Application Ref:	3/2026/0031			 Ribble Valley Borough Council <small>www.ribbonvalley.gov.uk</small>
Date Inspected:	06/02/2026	Site Notice:	06/02/2026	
Officer:	MC			
DELEGATED ITEM FILE REPORT:				APPROVAL

Development Description:	Planning permission for the installation of 2 no. new louvred grills to the side elevation of the property
Site Address/Location:	19 - 21 Berry Lane Longridge PR3 3JA

03 Side elevation
scale 1:50 @ A1

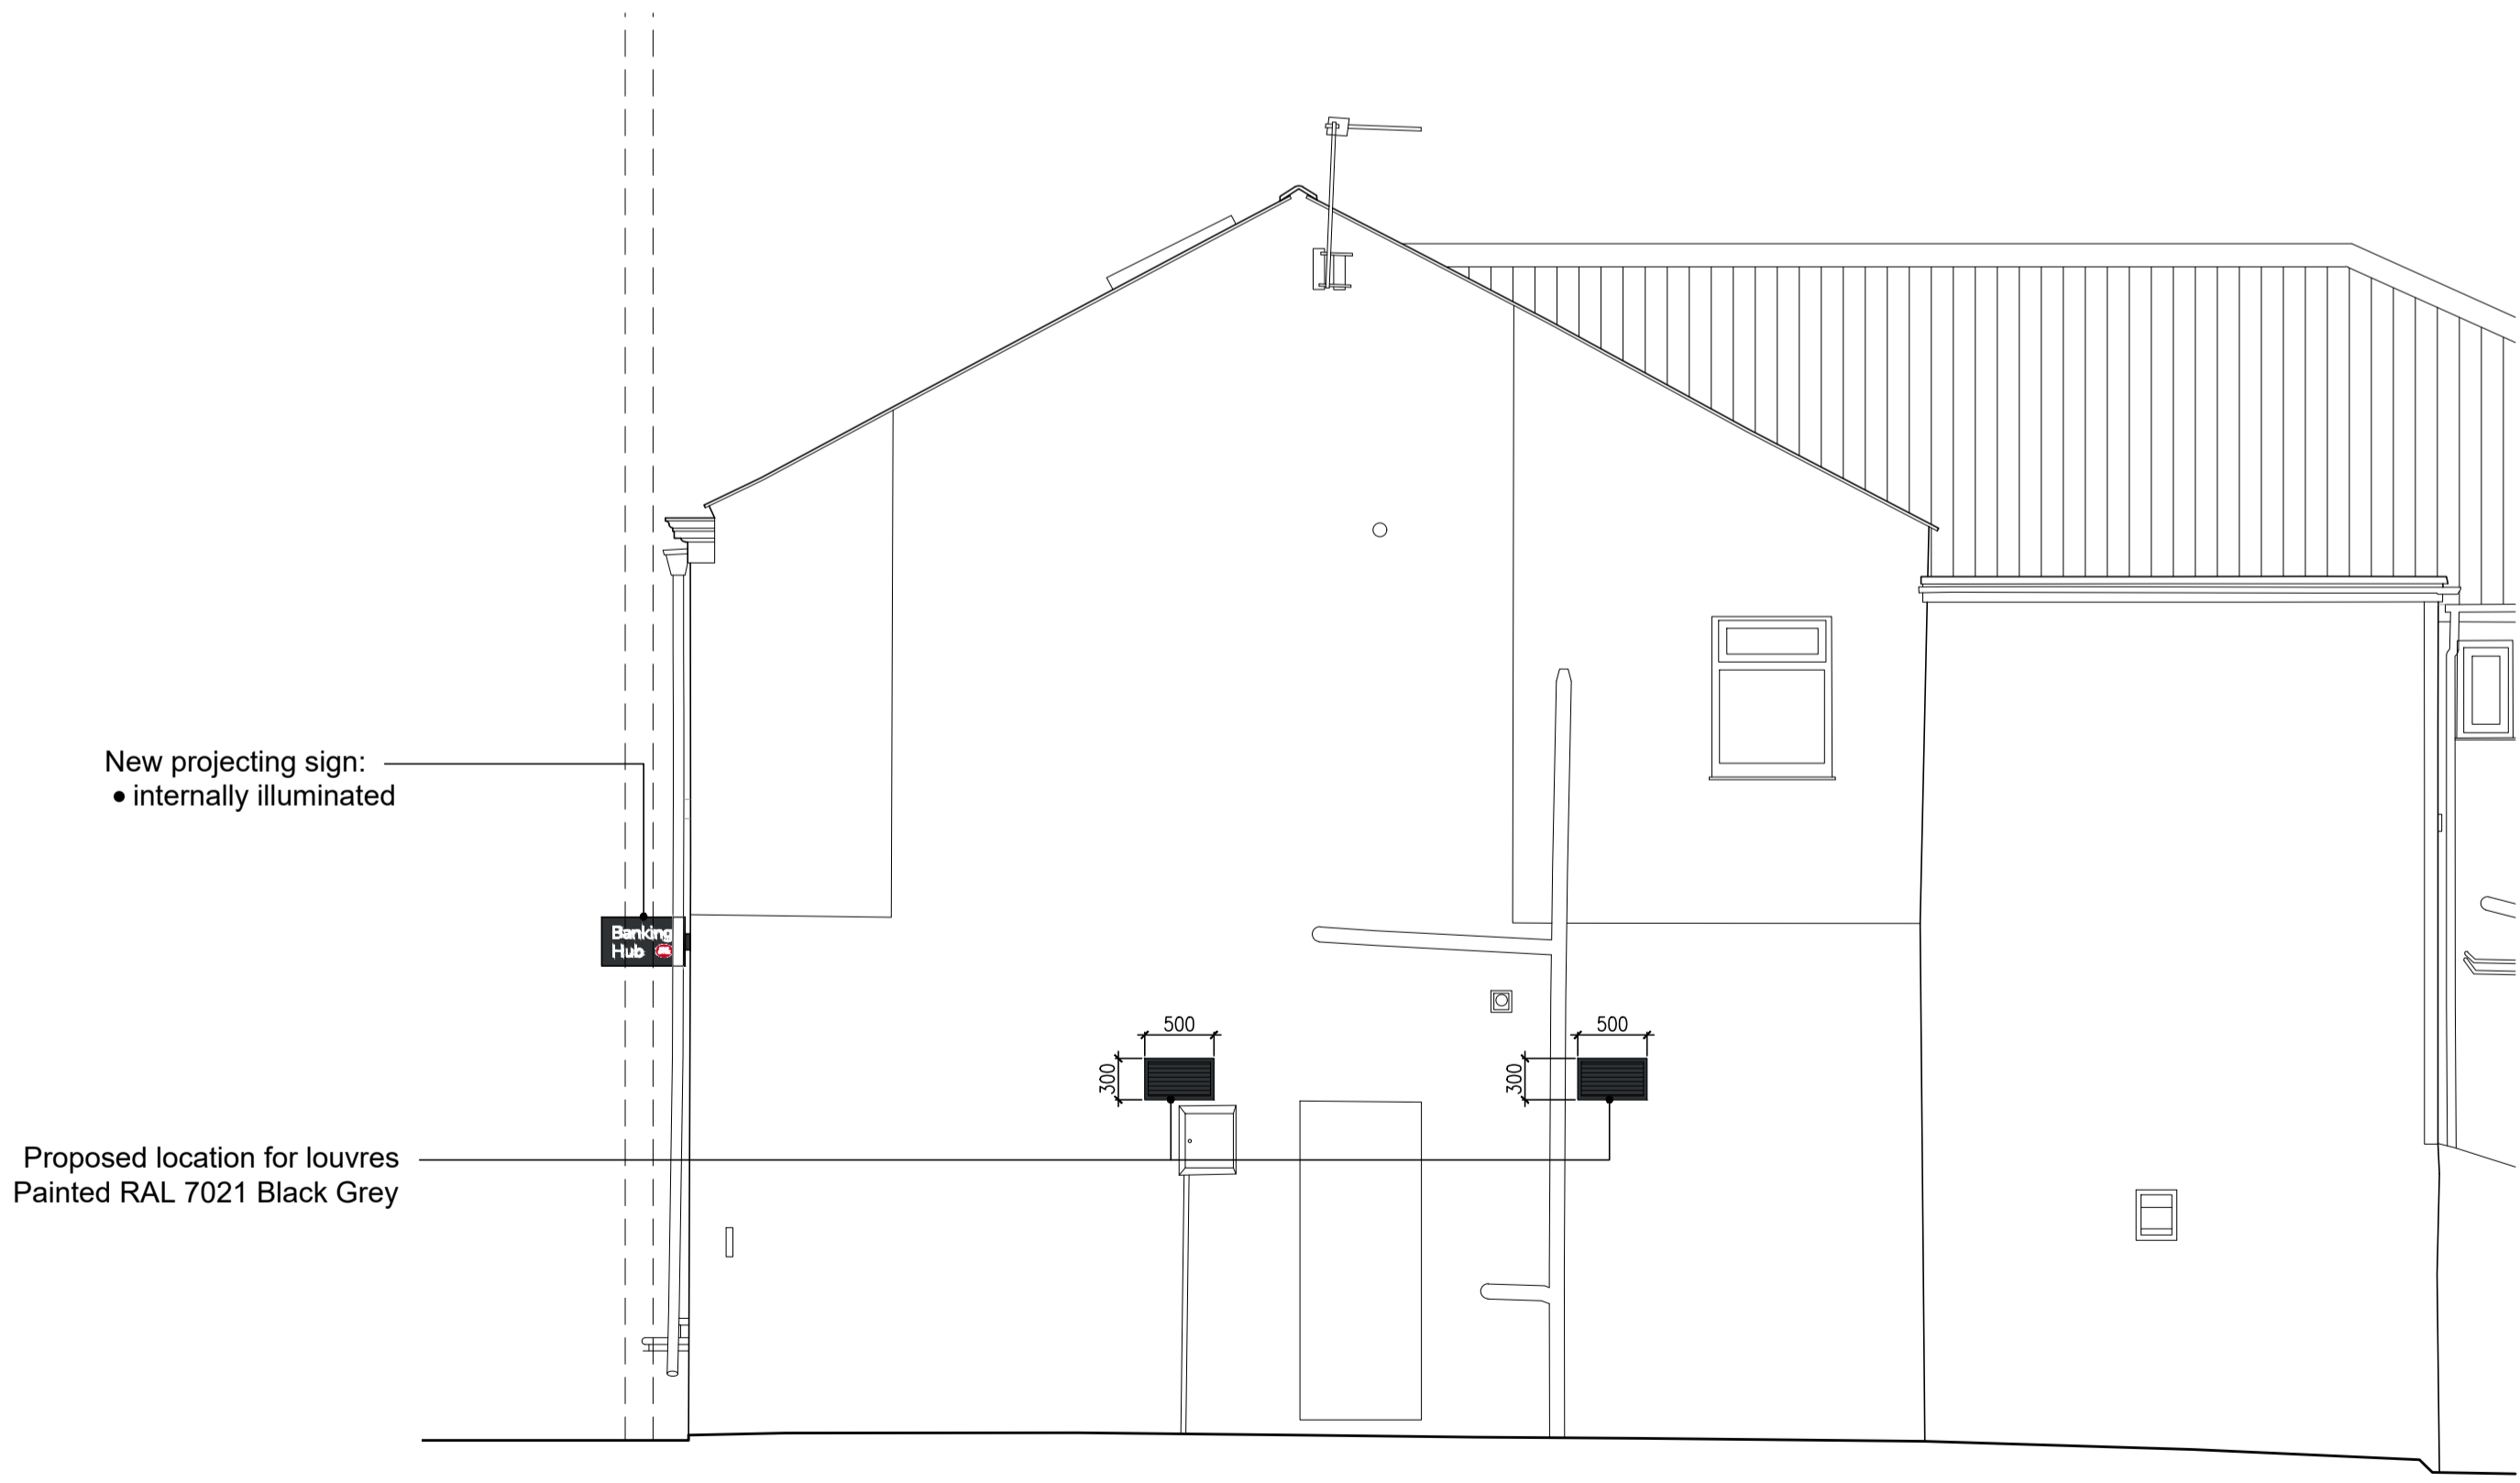
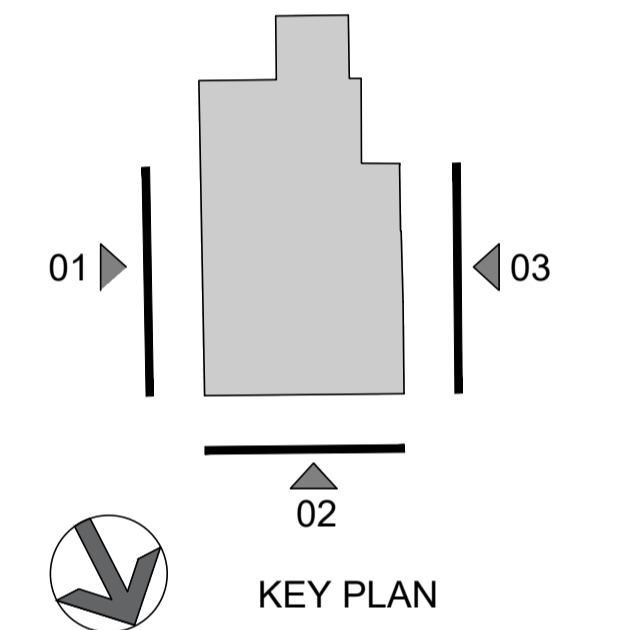
CONSULTATIONS:	Highways/Water Authority/Other Bodies
RVBC Environmental Health Officer:	Recommends a condition to ensure that the applicant shall fit acoustic louvres so that the sound level in the office achieves an LAeq of 45dB.

Consent is sought for the installation of 2 no. high level louvres painted RAL 7021 Black Grey to the proposed side elevation of the building facing no 23 and 23A Berry Lane. The louvred would be approximately 0.5m x 0.3m and would be set back from the front wall by approximately 3.3m. The rooms which the louvres would serve are an office and a disabled w/c.

The proposed louvres would be located on the flank wall and due to the close proximity of the adjacent building, they would not be highly visible from any viewpoints within the street scene. Due to the modest size of the louvres, it is not considered that there would be any adverse impact on the character of the existing building and the character and appearance of the Longridge Conservation Area is considered to be preserved.

The Environmental Health Officer has been consulted on the application and recommends that acoustic louvres so that the sound level in the office achieves an LAeq of 45dB.

Subject to the louvres being fitted with acoustic sound absorption, details of which can be secured by way of planning condition, the proposal is not considered to adversely impact existing residential properties adjacent to the site at first floor level in accordance with Policy DMG1 of the Ribble Valley Core Strategy and Policy LNDP3 of the Longridge Neighbourhood Plan.
